Please upload the email below from the applicant and the revised drainage plans that are attached to this email onto Ocella for BE/21/20/DOC – Salt Box.

Engineers comments in respect to surface water drainage;

APPLICATION NO: BE/21/20/DOC

Site Address: Land At Salt Box West Of Shripney Road Bognor Regis PO22 9NW

UNIT 4-8 FC-401
FLOW CONTROL IN CIRCULAR MANHOLE
SCALE 1:20

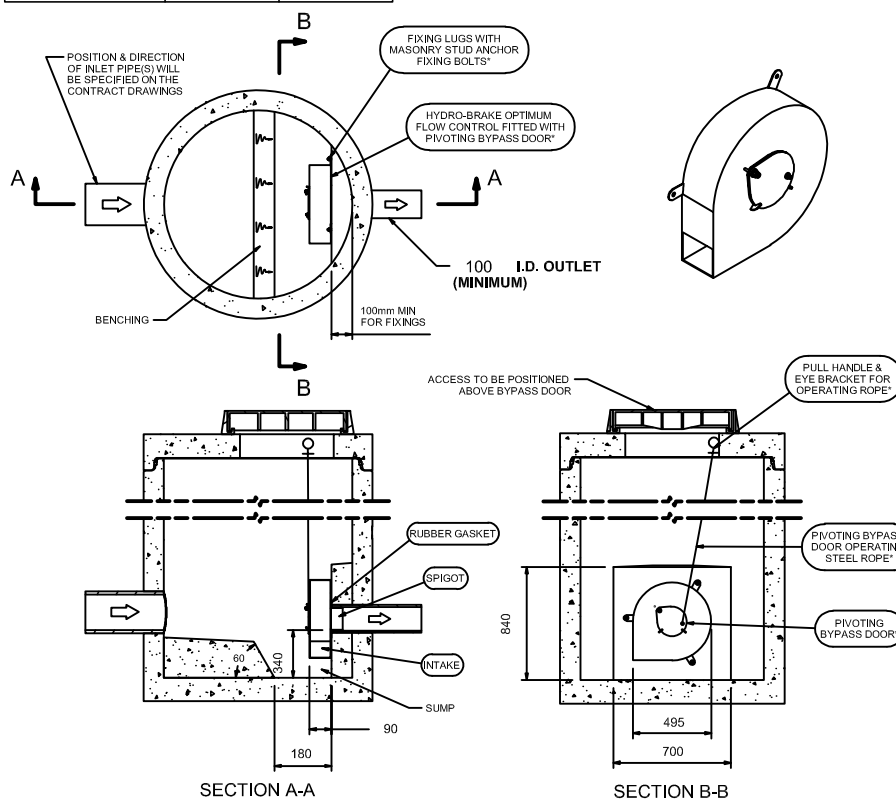
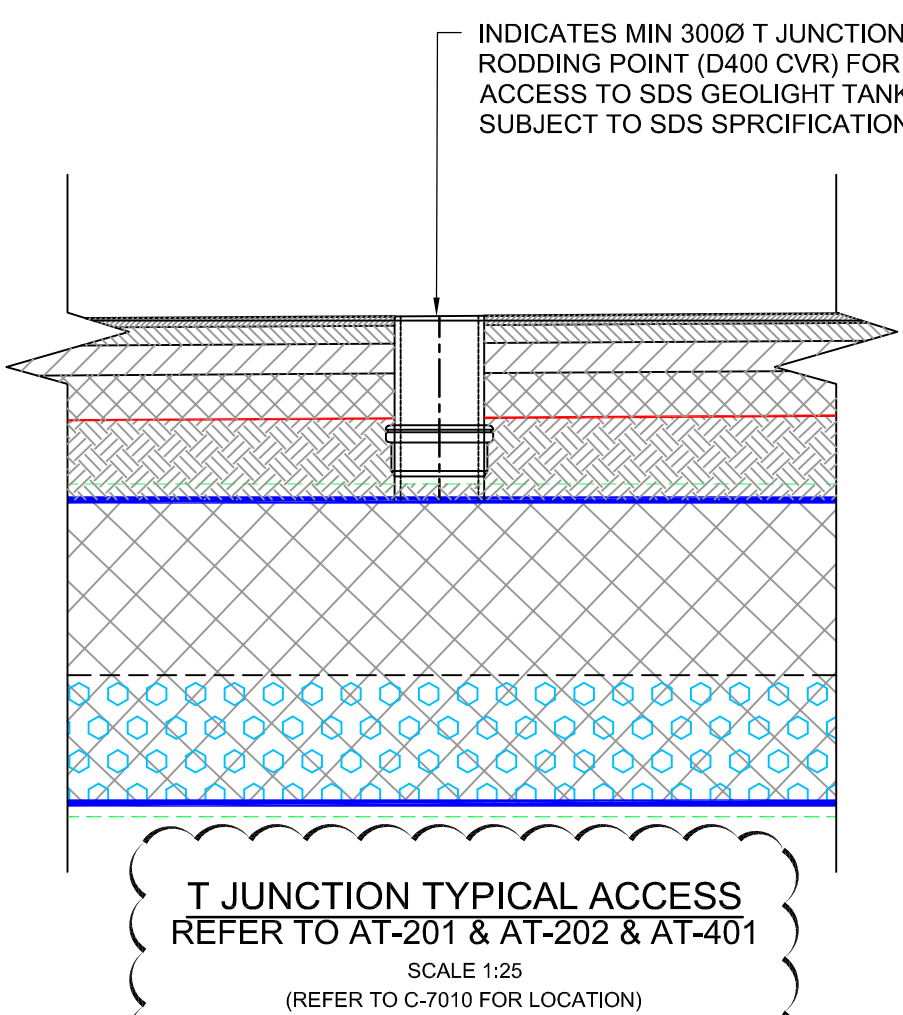
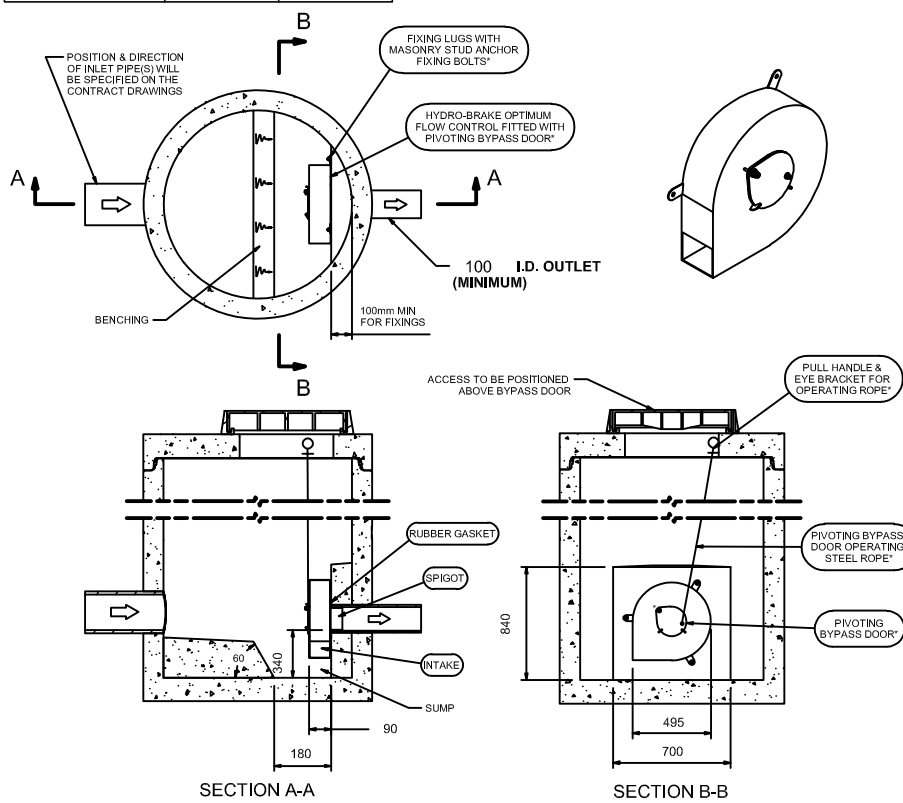
22. FC-401 – specify hydrobrake model and discharge on drawing 7103 (Phase 2)
Full detail can be found on drawing 7103. Flow note added. Now shown on 7101 but hydrobrake model not indicated? Model added.

SECTION 2-2
SECTION THROUGH AT-401
SCALE 1:25
(REFER TO C-7010 FOR LOCATION)

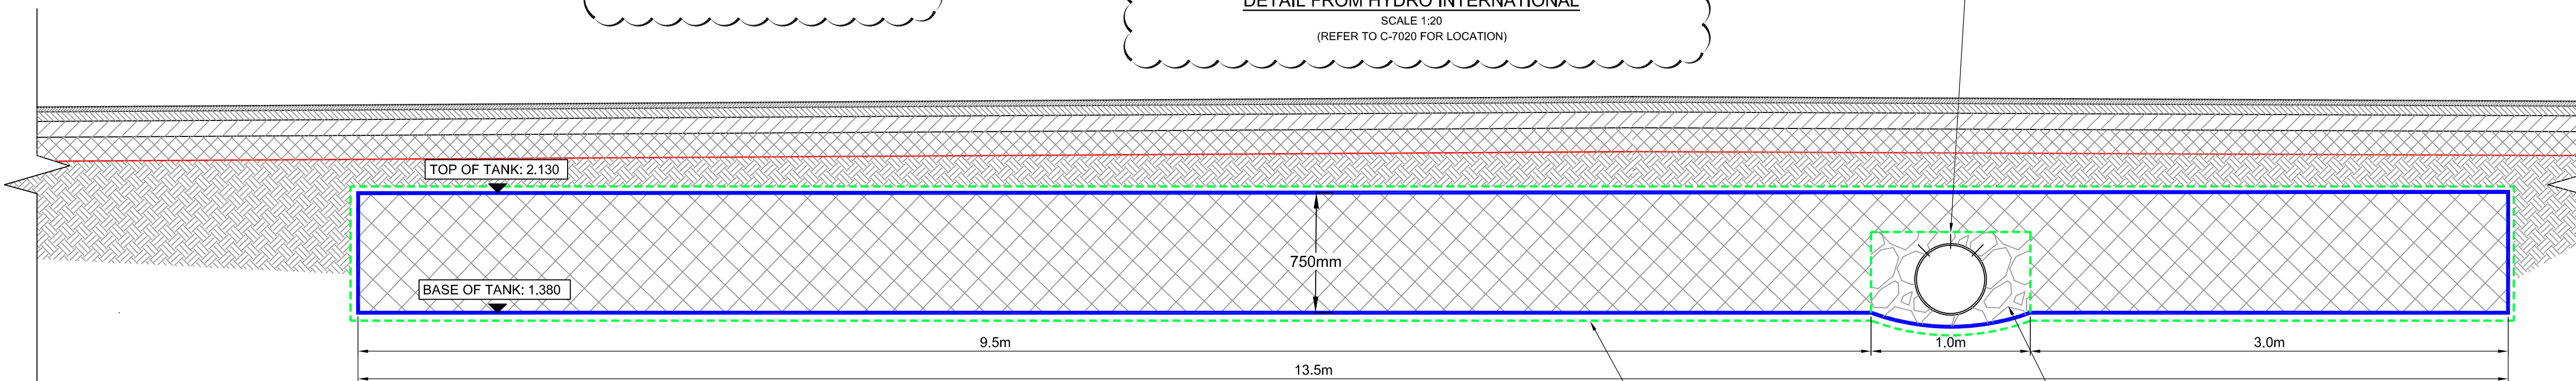
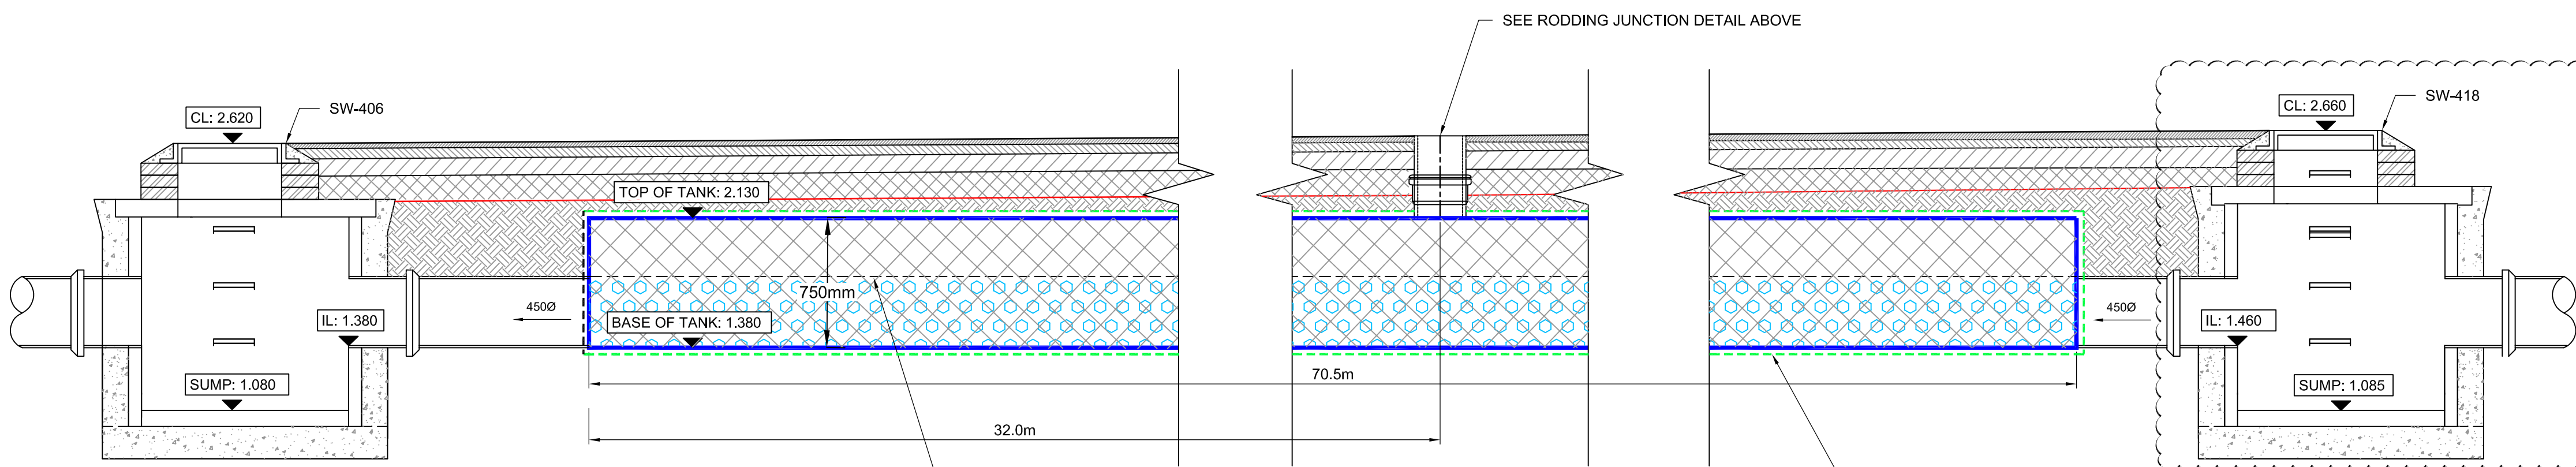
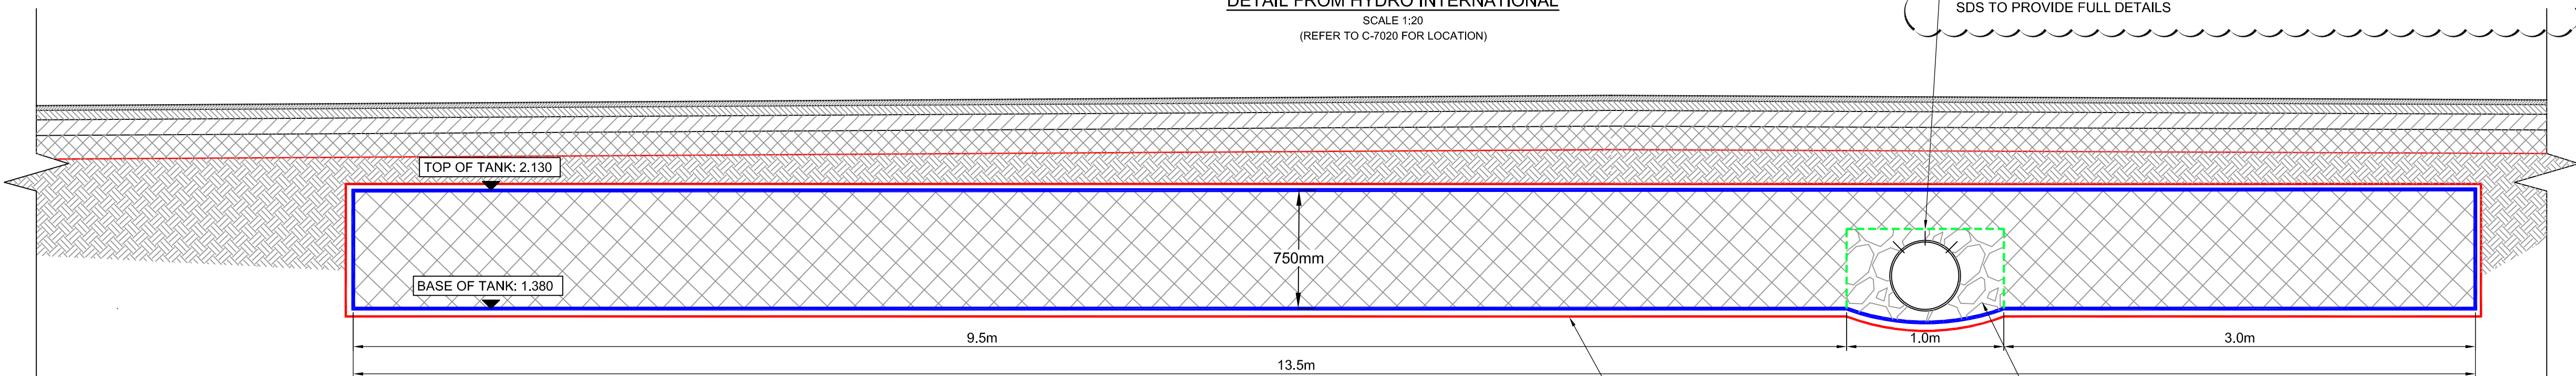
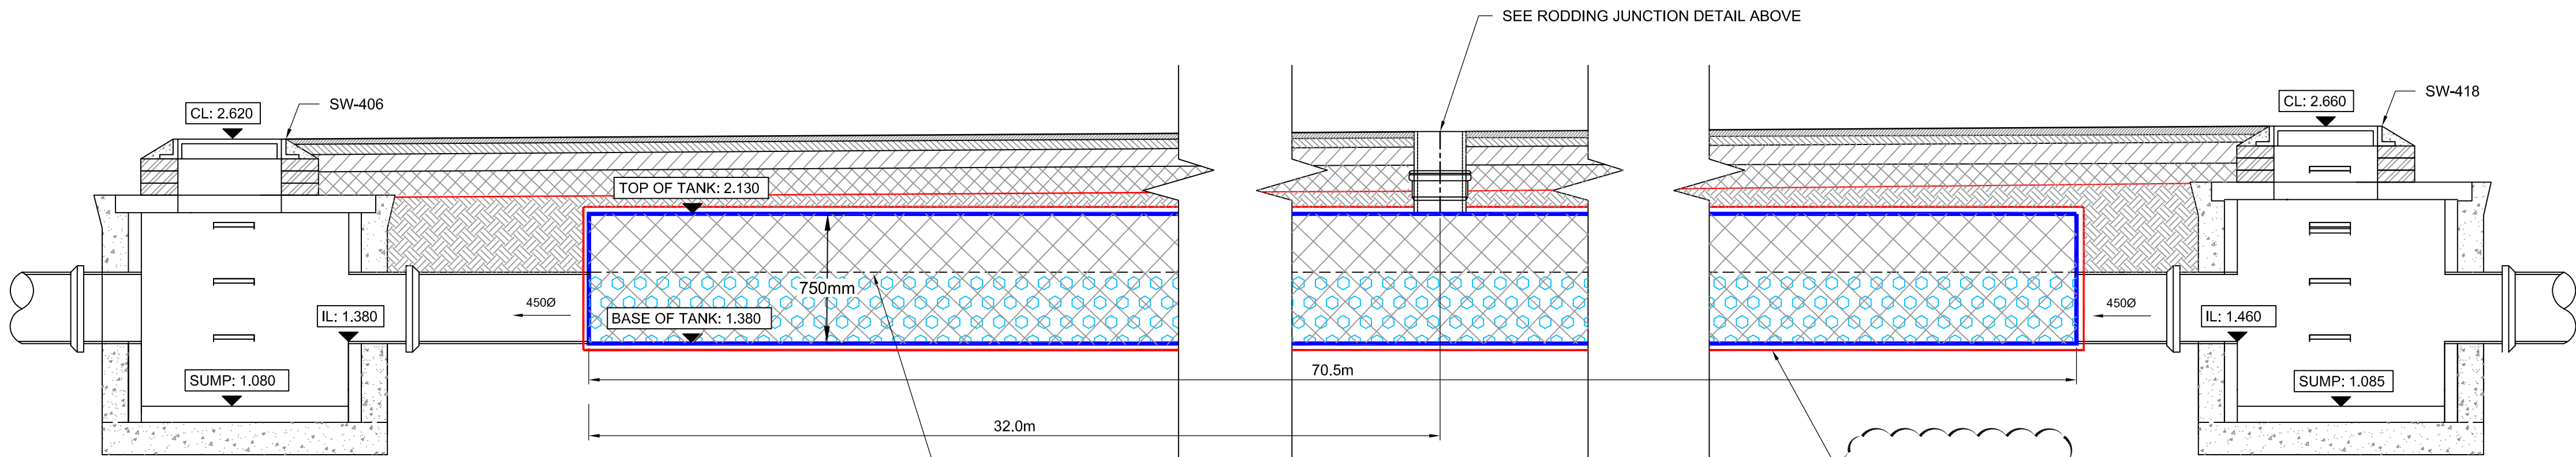
16. Drawing 7103 (Phase 2)– Section 2-2 – should this be labelled AT-401?

17. Drawings 7103 (Phase 1 & 2) ie. AT-201 and AT-401 – specify granular surround to pipe including thickness. Provide permeable geotextile wrapping to bedding.
Granular material detail note added and permeable textile wrapping note added. Done for AT-401. AT-201 – no drawing supplied? Added to AT-201.

18. AT-401 – Provide integral catchpit manhole in crates at connecting junction as opposed to a 300mm vertical pipe.
SDS tanks do not have a tank spec that allows for manholes to be installed within the tank but can provide a rodding access similar to what is shown and they allow for junctions in the pipe. ok but T junction access detail needs to refer to AT-401. Note added.

401 label added. ok
